# CITY OF ALBUQUERQUE

Site: Ladera Self Storage-2100 Ladera Rd NW

**Re: Drainage Ordinance (14-5-2-1) Violation for Erosion and Sediment Control**

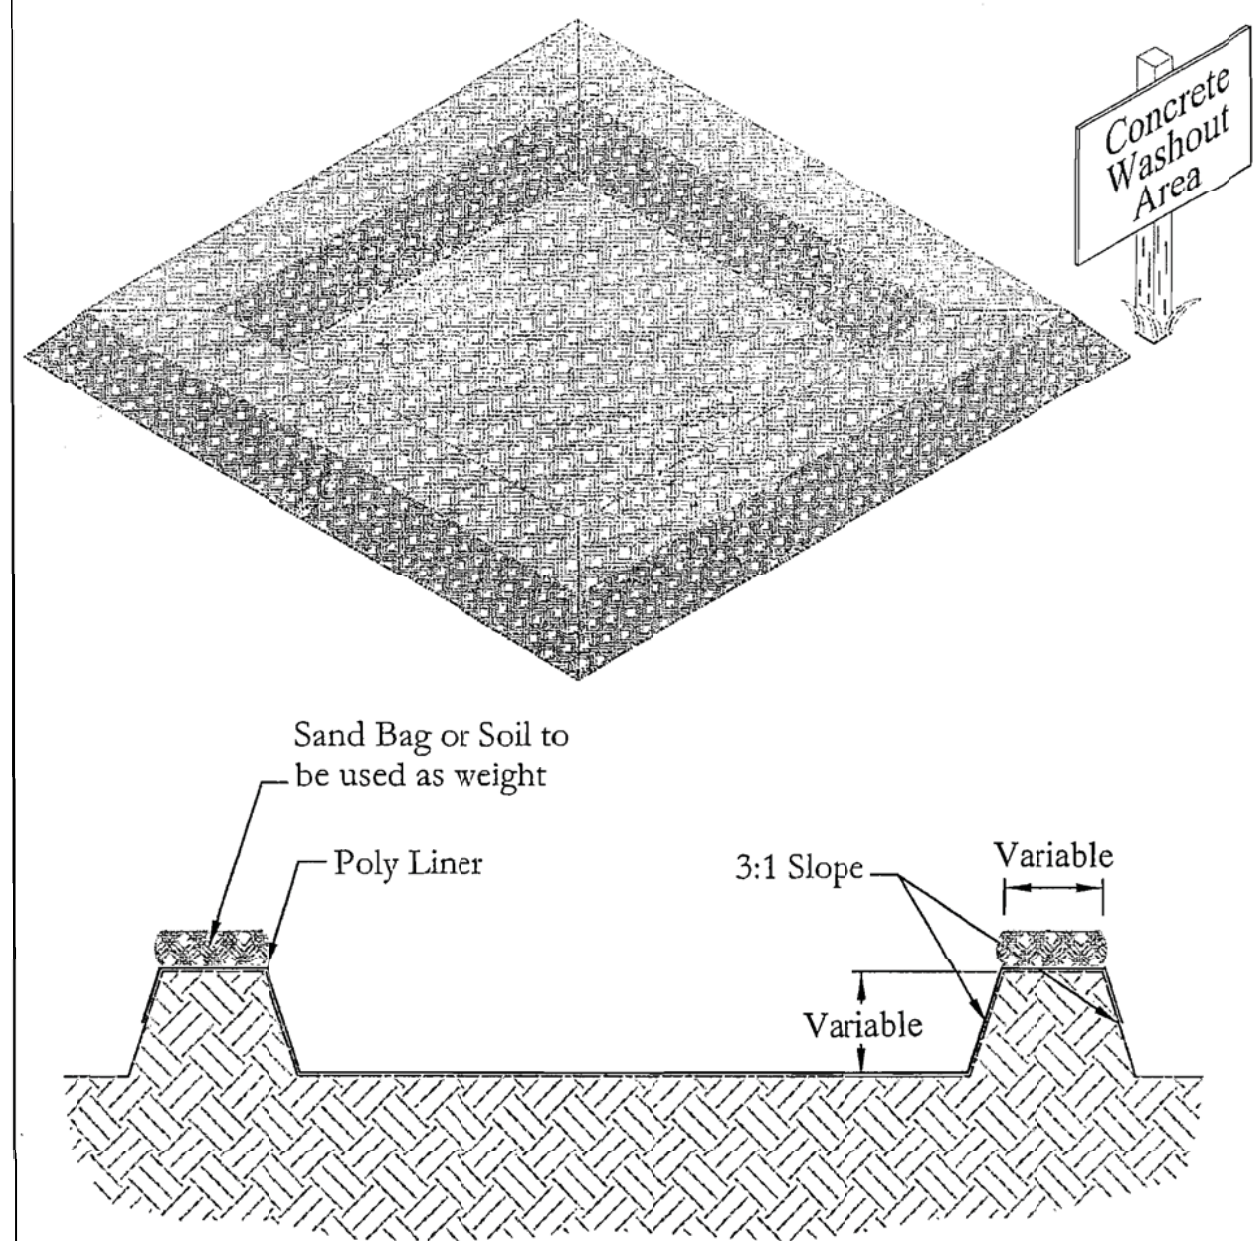
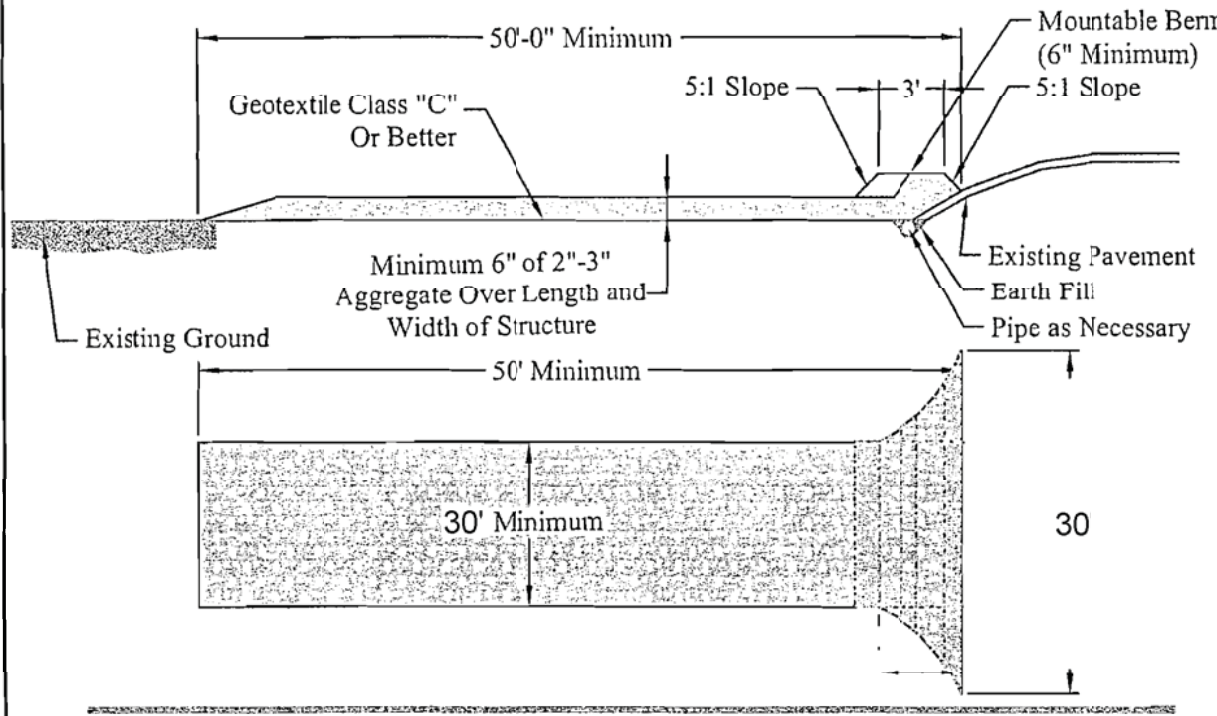
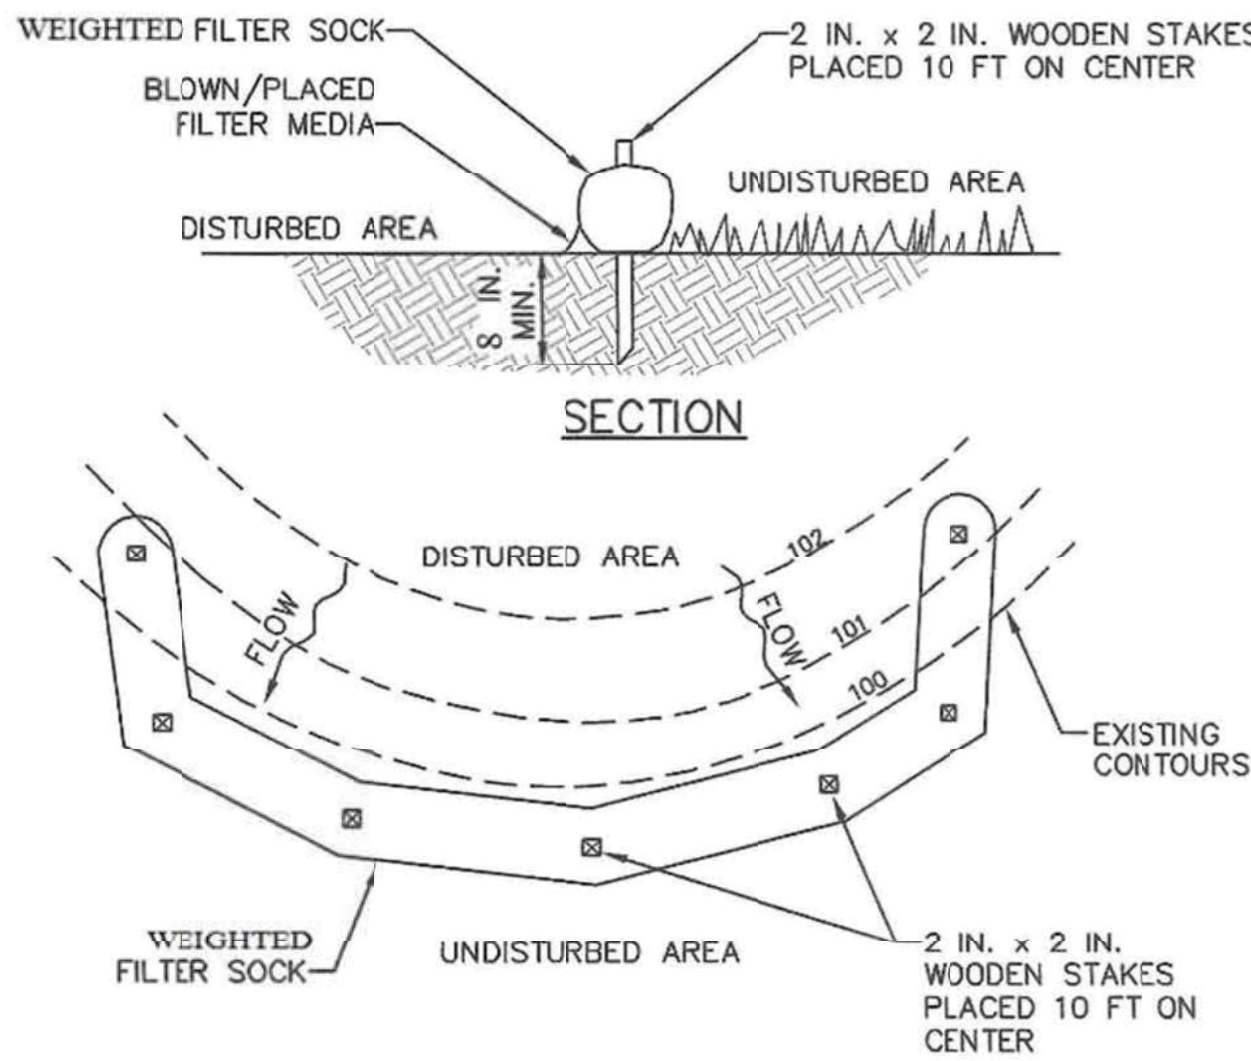
1. Earth disturbance has begun at the site and stormwater controls have not been implemented.

Site exit with no vehicle tracking control.

1. Implement stormwater controls per approved Erosion and Sediment Control Plan.
